Appeal Decision

Appeal Ref: APP/R5510/D/21/3276162

4 Harvil Road, Ickenham UB10 8AJ

BLOCK PLAN
1:200

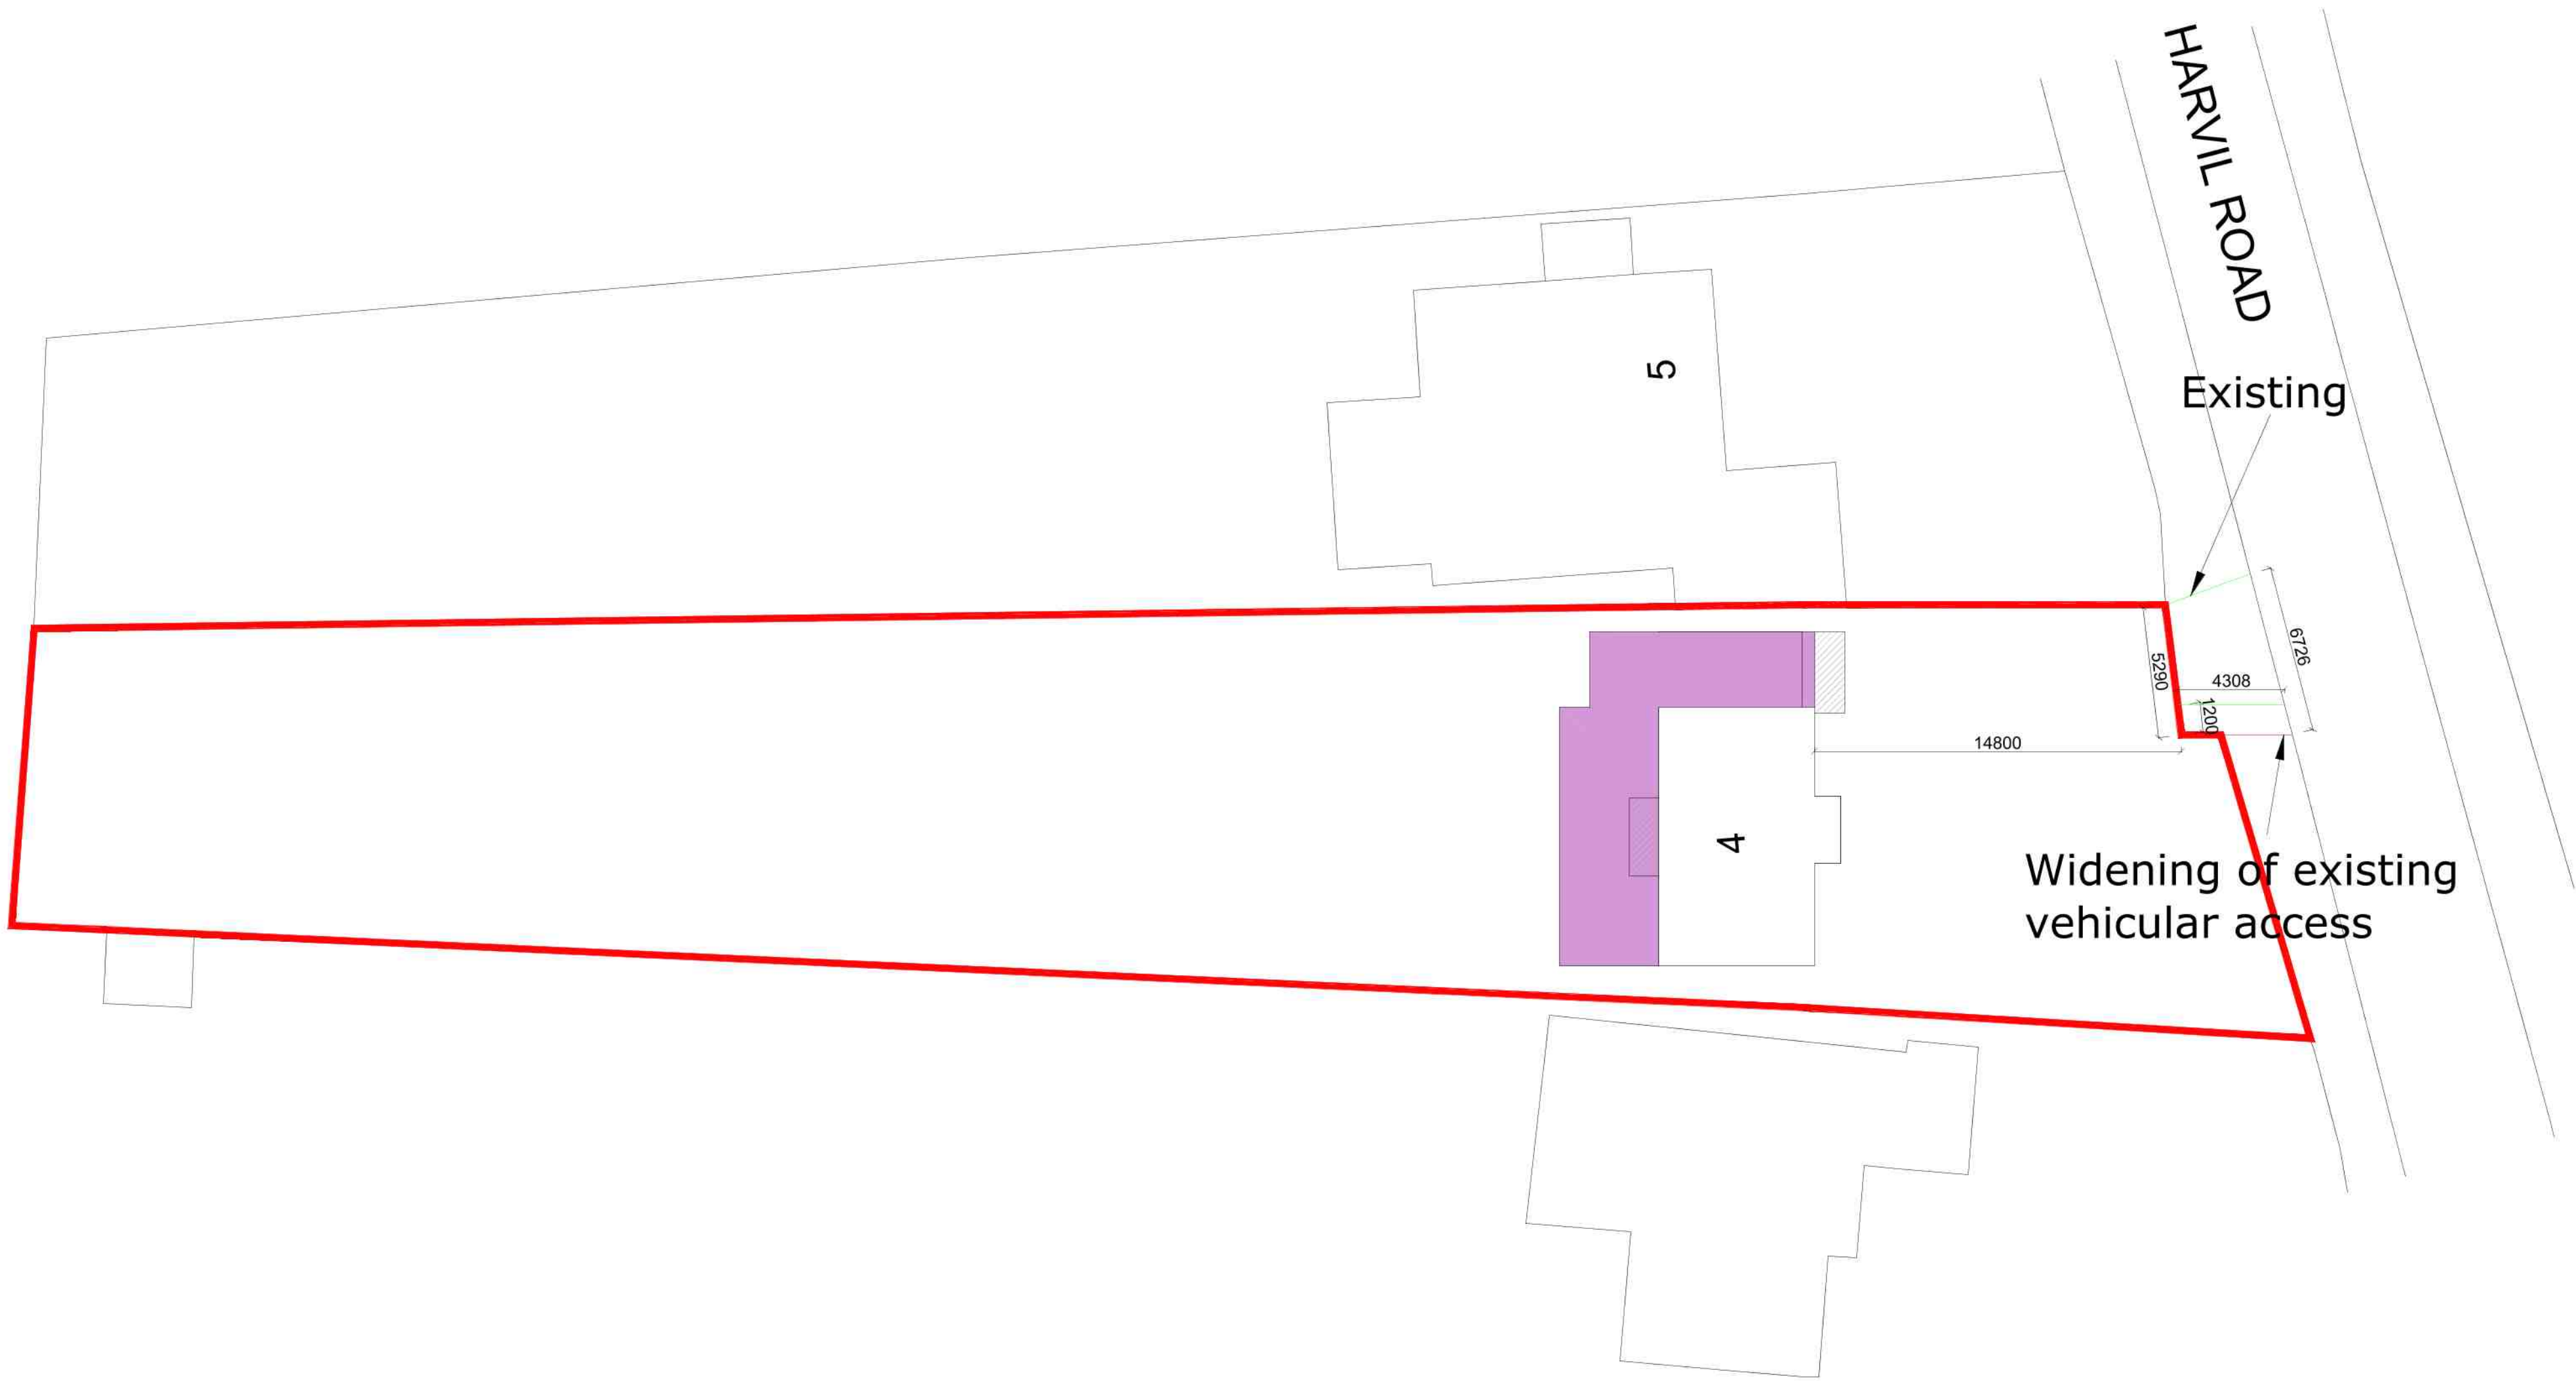
11. The proposal would involve the widening by 1.2m of the existing vehicular access/cross over from the site to 5.29m onto the adjacent highway where a 30mph speed limit applies. An established hedge runs along the front boundary of the site and the road in the vicinity of the access has a straight and wide alignment with street lighting and footpath provision.

13. From the evidence provided and from my observations on site, I consider that this section of Harvil Road is sufficiently safe and suitable to cater for the limited traffic movements from the host property. Due to the current configuration of the site and the proposed access arrangements, vehicles moving into and out of the site would be travelling and manoeuvring at low speeds. The current road conditions on the straight section of this residential road would allow sufficient visibility for vehicles to enter and leave the site safely and minimise any conflicts between traffic and cyclists or pedestrians.
